Application: **Sydney Metro West - Westmead to The Bays and Sydney CBD, Environmental Impact Statement, Five Dock Station**  
Application Number: **SSI-10038**

This submission is made on behalf of the Five Dock Public School Parents & Citizens (P&C) Association, which represents the parents and carers of the 400 plus students at Five Dock Public School and other members of the school community, including local residents.

FDPS P&C however would like to respond formally on the currently displayed "Sydney Metro West - Environmental Impact Statement" (EIS) document, highlighting the omissions, and recommending inclusions, to ensure the safety of our students and community during the proposed 24 month construction period from Quarter 4 2021 to Quarter 3 2023.

Figure 9-28: Five Dock Station indicative construction site layout

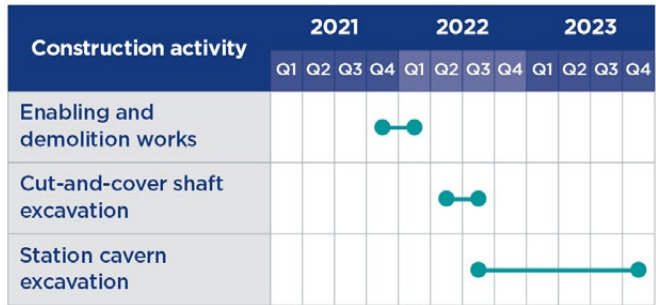
- Crossing guards (commonly known as lollipop ladies) between 8am and 9:30am and 2:30pm to 4:00pm, at the below sites
  - on ingress and egress of both the Eastern and Western Construction Sites on Great North Road, Second Avenue and Waterview Street
  - raised zebra crossing across Great North Road near Henry Street
  - four way intersection between Great North Road, First Avenue and Ramsay Road
  - intersection between Great North Road and Queens Road
- Installation of pedestrian crossing on West Street on the corner of Lancelot Street in advance of new public access walkway link between East Street and West Street (which also connects to requested traffic calming of West Street under Traffic Impact Requests below)

- For the start of Cut-and-Cover shaft excavation in Q2 2022, conversion of the raised zebra crossing across Great North Road near Henry Street to a signalled crossing
- For the start of Cut-and-Cover shaft excavation in Q2 2022, the addition of a signalled crossing on Harris Road at the end of Garfield Street, to allow the safe crossing of students to the Kings Park housing precinct and the future Kings Bay precinct development
- The approval, construction and funding of a “Kiss and Drop” area for FDPS on crown land on Henry Street on the northern side of the all-weather purpose court
- Greater detail provided regarding the interaction and management of pedestrians and construction vehicles entering the Western Site on Great North Road

- No departure of heavy construction vehicles from the acoustic sheds during peak school zone times, between 8am and 9:30am and 2:30pm to 4:00pm
- An agreed location with the community for a “truck marshalling area” in a non-residential area, where heavy construction vehicles will wait before entering the Western and Eastern sites for spoil removal. This is not detailed in the EIS, and is important to know in order to prevent construction vehicles parking on any roads in the precinct and to address pedestrian and traffic movement recommendations

- 100% compliance that construction vehicles leaving the Western or Eastern sites with loose spoil cannot leave the acoustic shed without a fixed cover over the load and all top rails and tail gates cleaned of any loose spoil
- No departure of heavy construction vehicles from the acoustic sheds during peak school pedestrian travel hours, between 8:30am to 9:30am and 2:30pm to 4.00pm
- Truck tyres to be washed down before exiting site, so construction spoil and dust is not trailed through local streets

- Traffic calming measures implemented on West Street and Scott Street, to prevent "rat running" on local access roads around the school. This is especially important as the pedestrian entry to FDPS Preschool and Out of School Hours Care is on West Street

- The essential addition of a two stage airlock door on both the Western and Eastern Site to reduce the noise from the construction site and impact on students learning at FDPS and students who live directly next to the site
